CITY OF ALBUQUERQUE

Re: Encino Gardens Renovation
412 Alvarado DR SE
Traffic Circulation Layout
Architect's Stamp 10-02-23 (K18D002)

Based upon the information provided in your submittal received 10-3-23, the above referenced plan cannot be approved for Building Permit until the following comments are addressed:

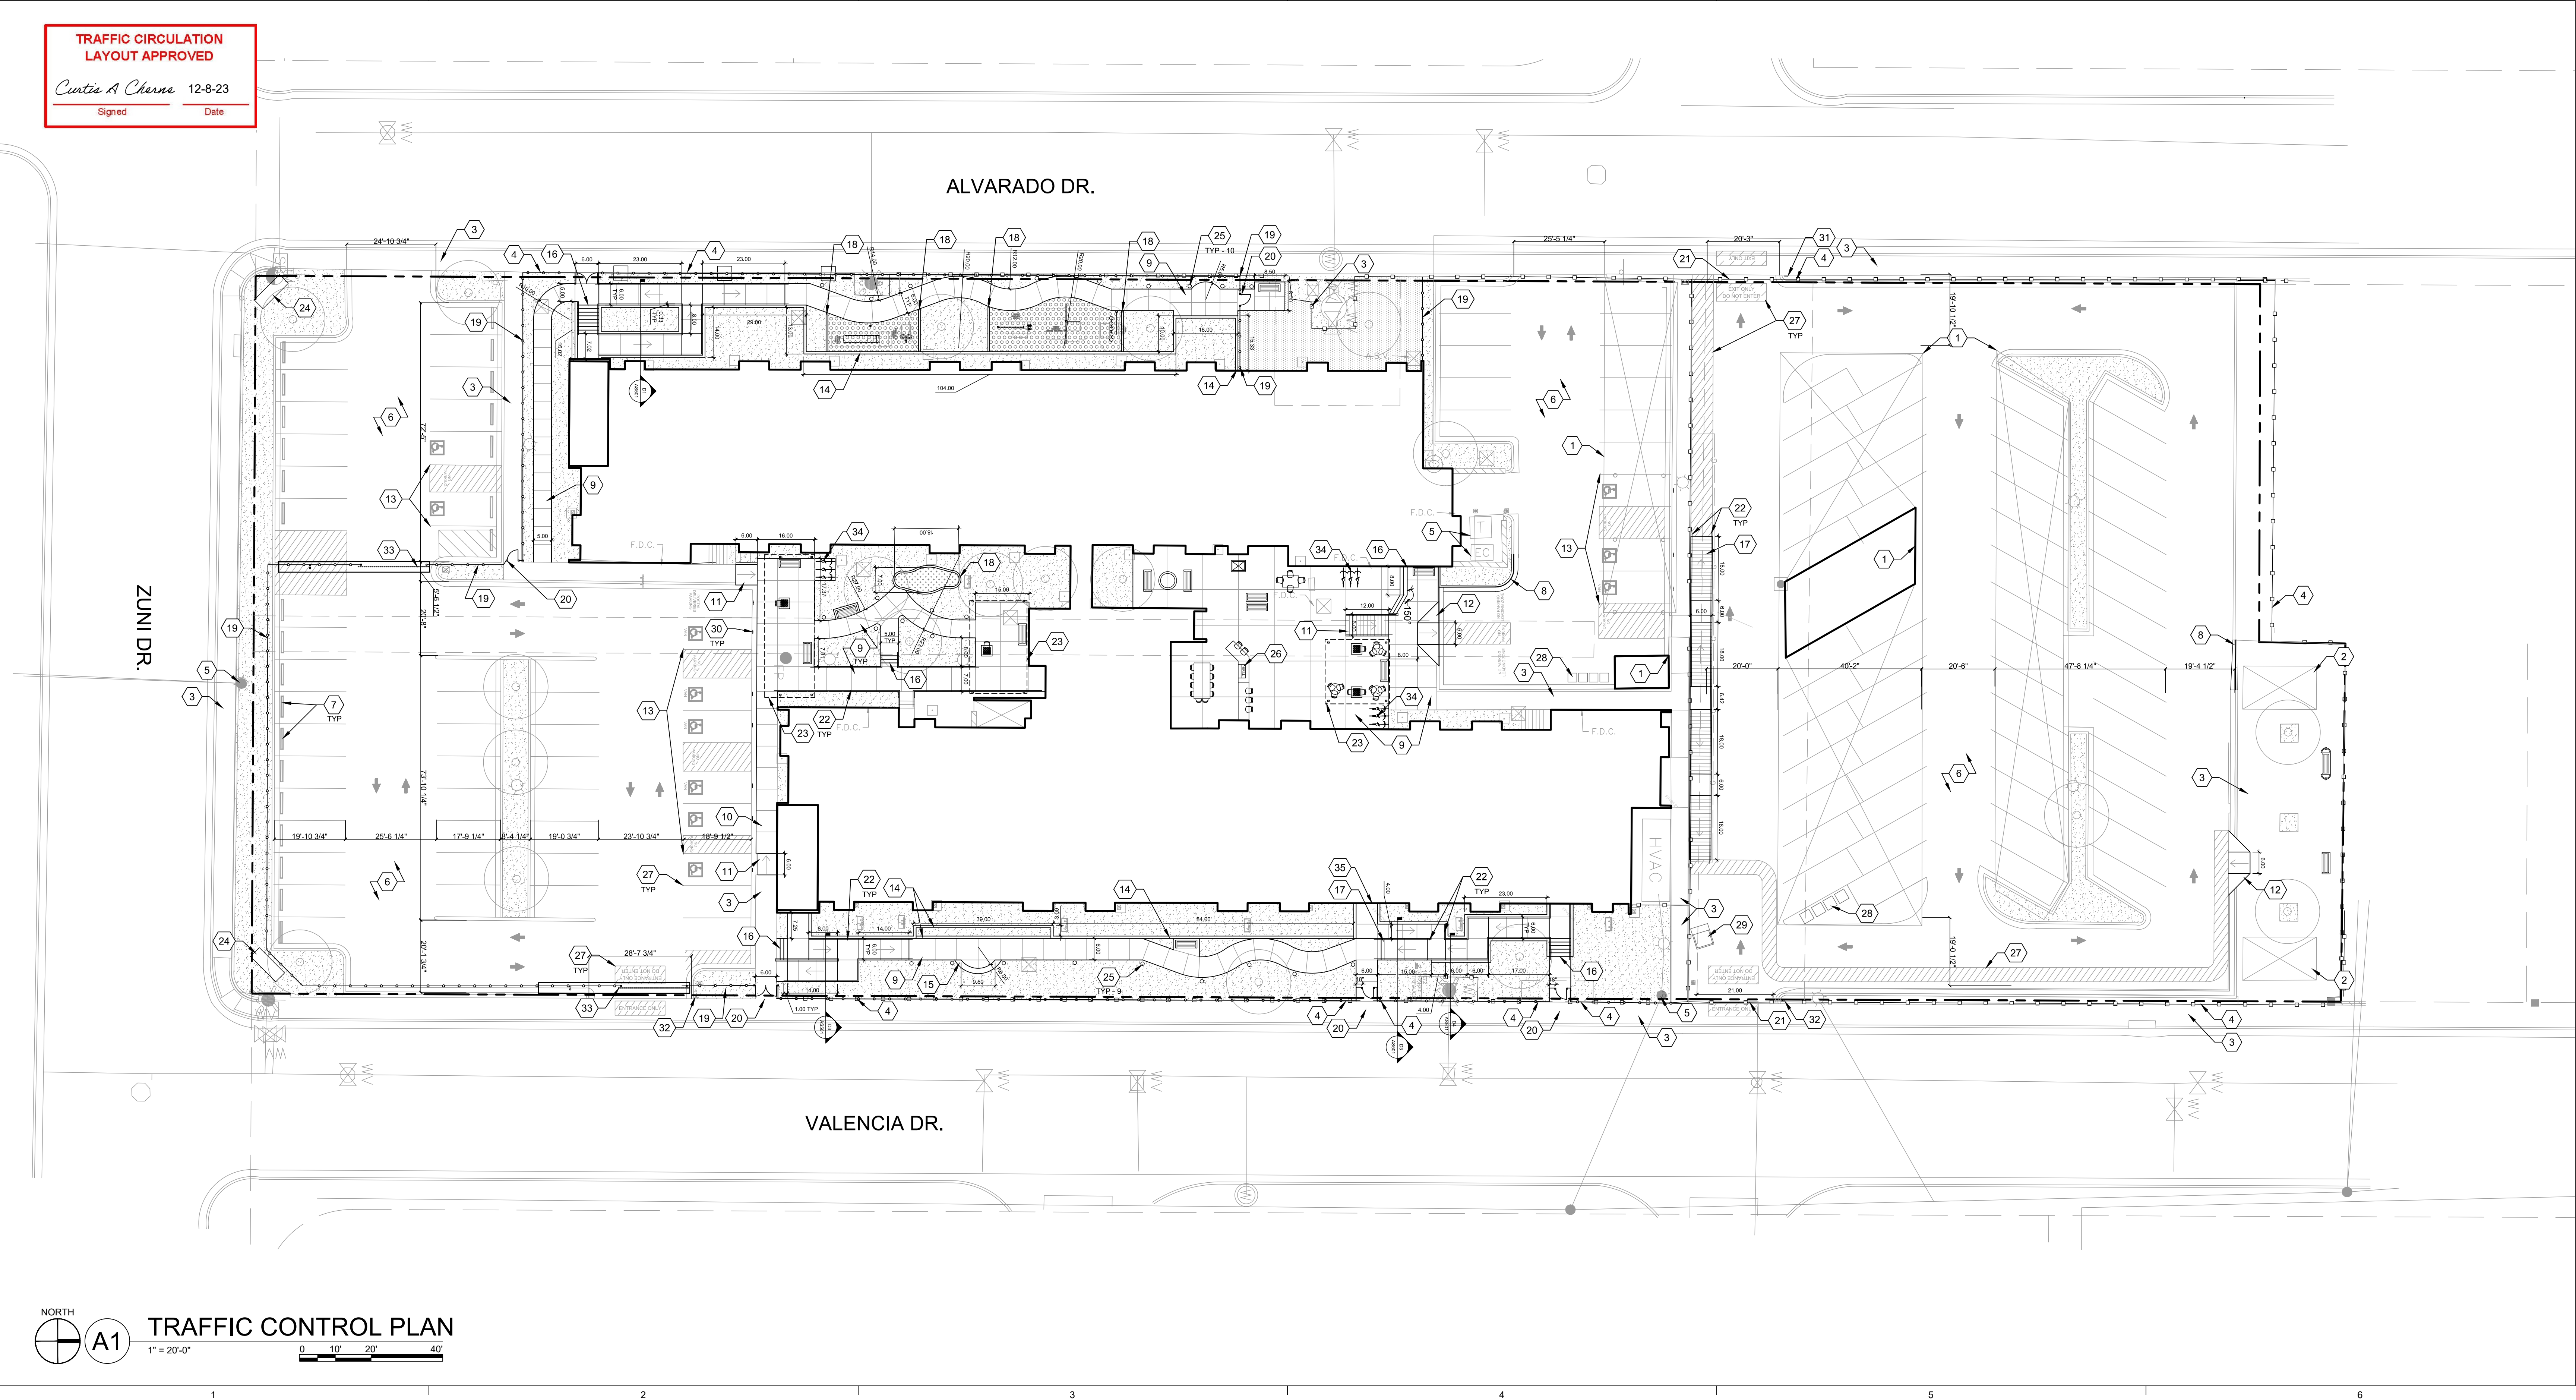
1. Since you are proposing gates, forward Fire Department approval.
2. Forward Solid waste approval.
3. In general, provide all ramp and landing slopes and sidewalk widths.
4. Provide signage in addition to pavement markings for the one-way exits and entrances: "One Way" and "Do Not Enter".
5. You will need a ramp at each end of the sidewalk that is being reconstructed (Keyed Note 3). Provide max ramp slopes. Max slope is 8.3%, but it is best to design to a lower maximum: 7.5%.
6. It is usually helpful to provide a detail of the layout of ADA Accessible parking. See below:

7. Provide guidance for the HC signage on the plan. See attached Accessible checklist, page 3.

8. Please verify the sidewalk width at Keyed Note 7 as it is drawn narrower at the public sidewalk.
9. Provide max slopes for Keyed Notes 5, 7, 8, 15, 16, 21, 30, 36, 43.

10. For keyed note 36, there should be a landing: minimum sized 4'x4' and max slopes in all directions 2.0%, but better to design to 1.5%.
11. "Access aisles" and "accessible routes" should be labeled "ADA Accessible Routes" (e.g. Keyed Note 16, 42 and 43)

12. For the walkway Keyed Note 23, indicate what material to use for the paving.
13. It appeared the bicycle parking area could easily accommodate more bicycle parking.

14. Please check that the item for keyed Note 40 is on the plan.
15. For the ramps keyed Note 15 and 16, a flat ($\leq 2.0\%$) landing is required every 30 ft on a ramp and at the top and the bottom.

16. From my site visit, it appeared there was an existing space that could be used to provide one motorcycle parking space. The space is near the "9" that is printed on a parking space near the north entrance/exit on Alvarado Dr.

17. The linework at the east and west ends of the covered parking (12 spaces) does not match the site. Are there proposed changes?
18. It appears the intent in the north parking lot is to have one-way circulation, yet I did not see a Keyed Note for pavement markings or signage.

19. For the ADA accessible route to the north (Keyed Note 42), indicate a max cross-slope and width of the path.
